Our ref: RA/2022/144175/01-L01
Your ref: 2021/94721
Date: 09 March 2022

DISCHARGE OF CONDITION 4 (FLOOR/GROUND LEVELS AND DRAINAGE) OF PREVIOUS RESERVED MATTERS APPROVAL 2019/91638 FOR ERECTION OF 27 DWELLINGS PURSUANT TO OUTLINE PERMISSION 2017/92233 FOR ERECTION OF UP TO 34 DWELLINGS – LAND AT ABBEY ROAD NORTH, SHEPLEY, HUDDERSFIELD, HD8 8DY

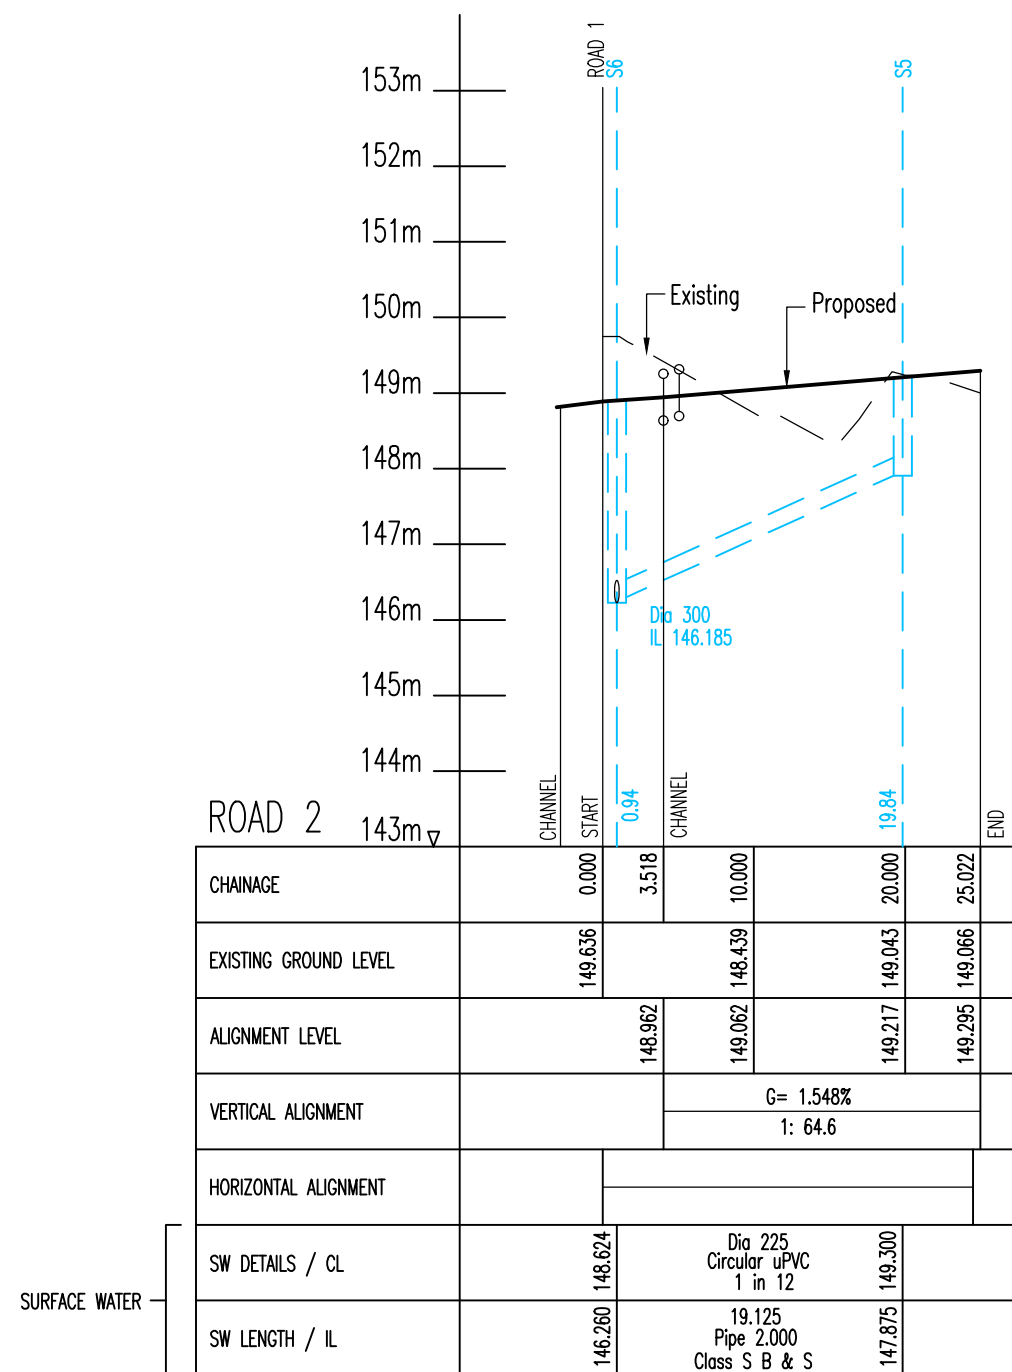
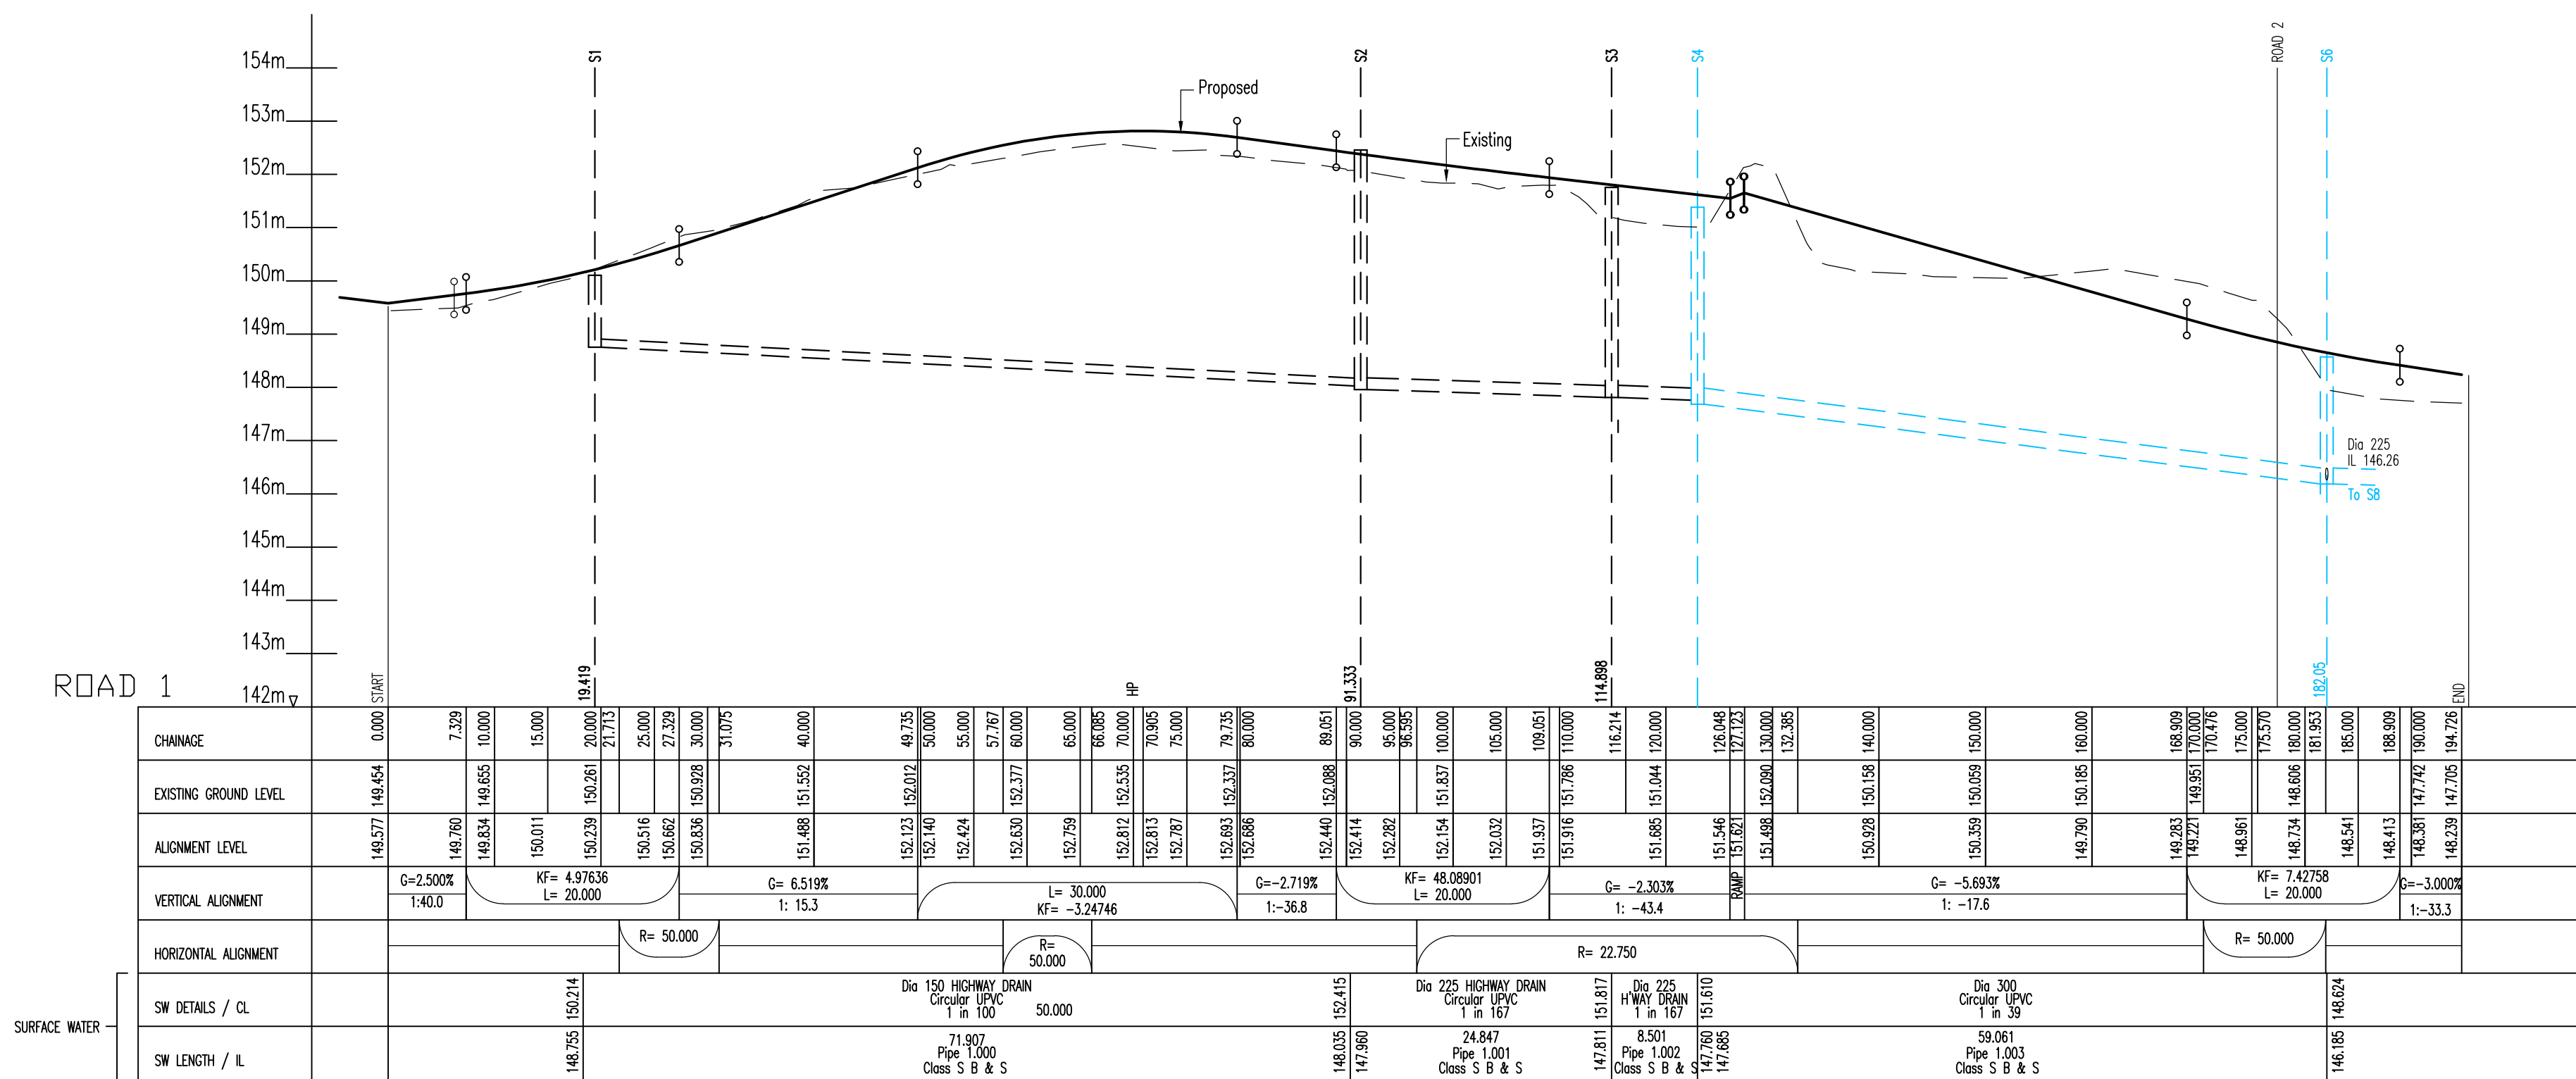
Longitude sections have been submitted to discharge condition 4 showing existing/ proposed ground levels, and ground reprofiling. However, the cross-section locations have not been referenced on a plan, so it is not clear where the ground level reprofiling is taking place.

Condition 23 states flood compensation storage shall be provided as detailed. The information submitted on ground reprofiling may not meet, and may adversely affect, the developer's ability to meet the requirements of condition 23 on compensatory storage to the 1% plus climate change level.
